FAO: Caroline Ford
Planning Officer
Cherwell District Council
Bodicote House

Planning application ref: 14/00005/SCOP; 14/00006/SCOP; 14/00007/SCOP
Application location: Various locations - NW Bicester
Scoping Opinion for development to provide residential dwellings, green space, a primary school, a secondary school, social and community facilities, an energy centre, commercial floorspace, amenity space and service infrastructure.

Thank you for consulting us on the above scoping opinion request. I have the following comments on behalf of the Berks, Bucks and Oxon Wildlife Trust. As a wildlife conservation focused organisation, our comments refer specifically to impacts on species and their habitats which may occur as a result of the proposed development. This response refers to all three of the above applications.

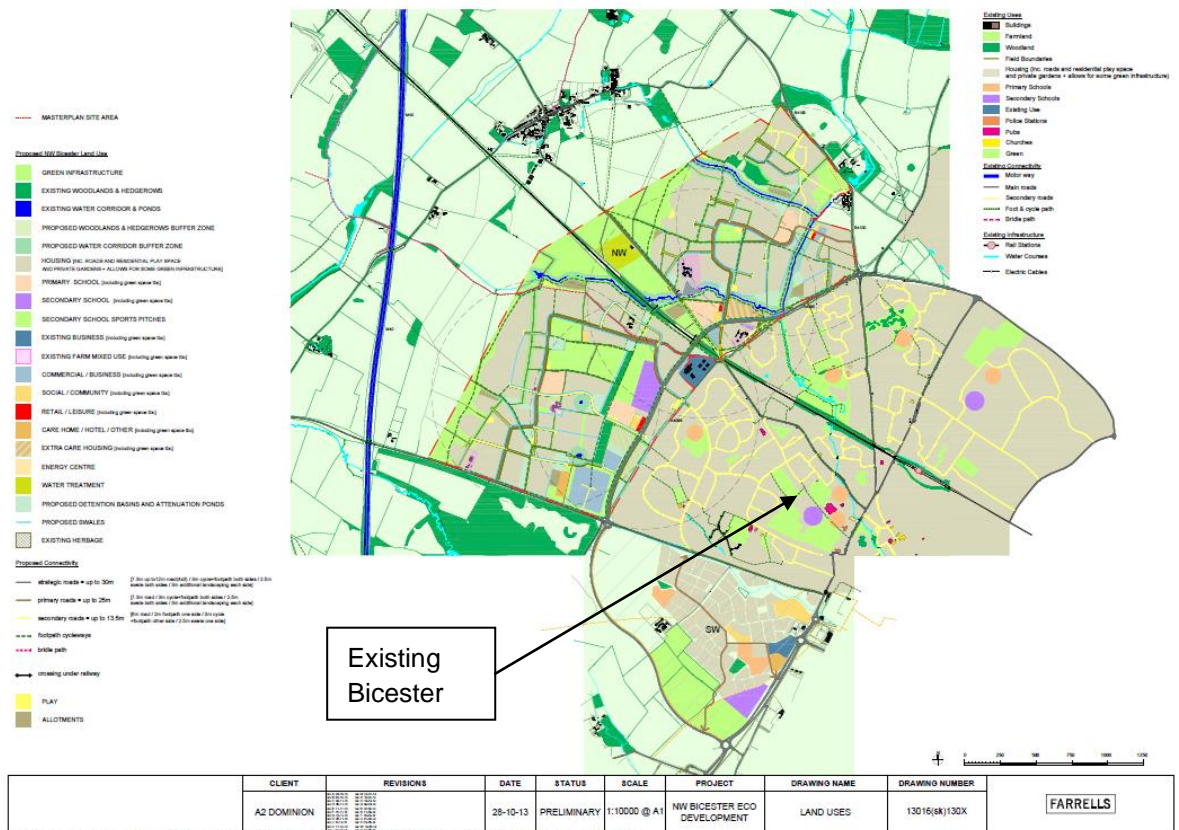
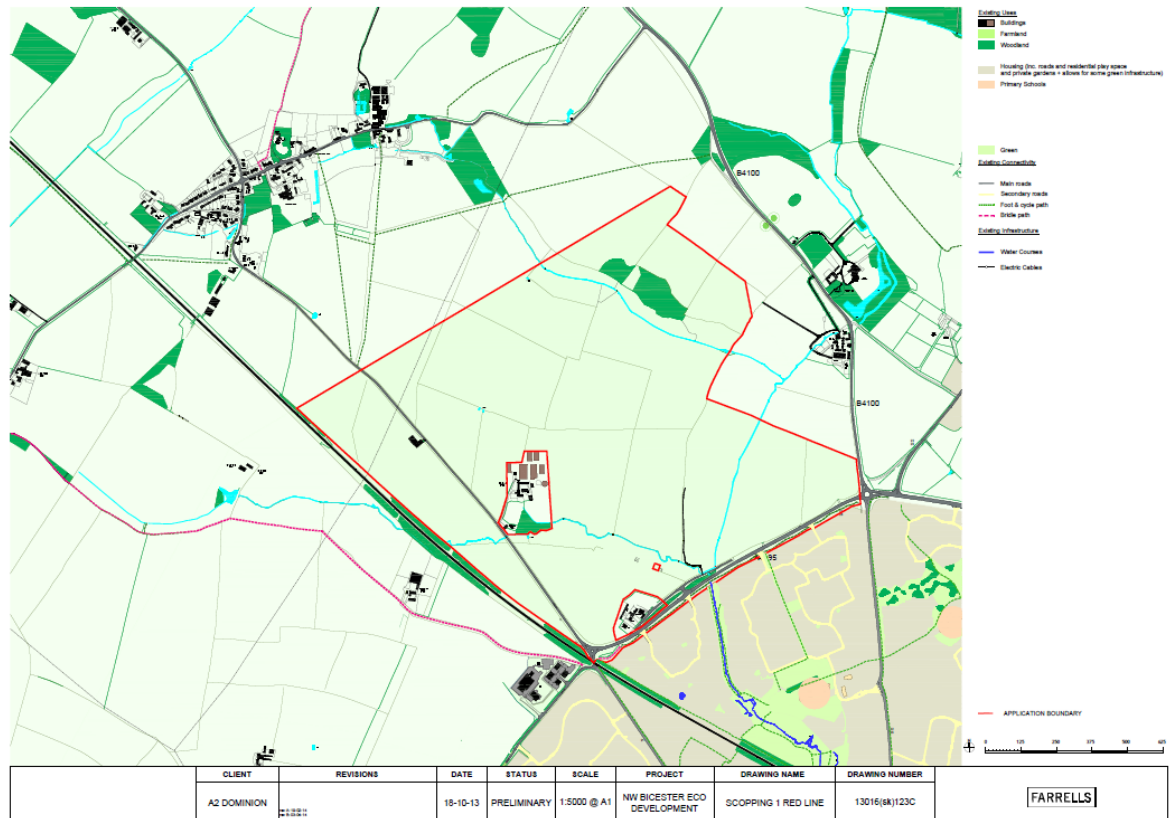
The EIAs should assess the impacts on Priority Habitats and Species, in addition to protected species (in line with paragraph 117 of the National Planning Policy Framework). The EIAs should also assess impacts on Local Wildlife Sites as well as statutory sites. Impacts at Local and Site level should be assessed in addition to those at District level and above.

The applicant **would need to demonstrate that a net gain in biodiversity would be delivered** (in line with the National Planning Policy Framework) using an accepted biodiversity metric in the EIAs.

The EIAs must show how lighting across the whole site is designed to minimise the impact on wildlife, and in particular so as not to shine into wildlife corridors.

All EIAs should include an assessment of cumulative impacts on ecology, both direct and non-direct impacts within the site and off-site.

Enhancements in biodiversity should be built into the design from an early stage on various scales, including individual house design. Features for biodiversity within the site should be planned to link up to habitats and features in the surrounding landscape. The EIA should demonstrate whether best practice has been followed, as suggested in the Oxfordshire Biodiversity & Planning Guidance.

Opportunities to include biodiversity within the built development should be maximised. In addition to green spaces this should include as many as possible of the following:

- SUDS schemes/balancing ponds to be designed so as to maximise their biodiversity value
- Bat and/or bird boxes within the fabric of buildings
- Green rooves on buildings where possible
- Street trees, and fruit trees in gardens
- Native wildflower meadows and other wildlife habitats within the street environment, ideally within gardens and also within the grounds of any public buildings.
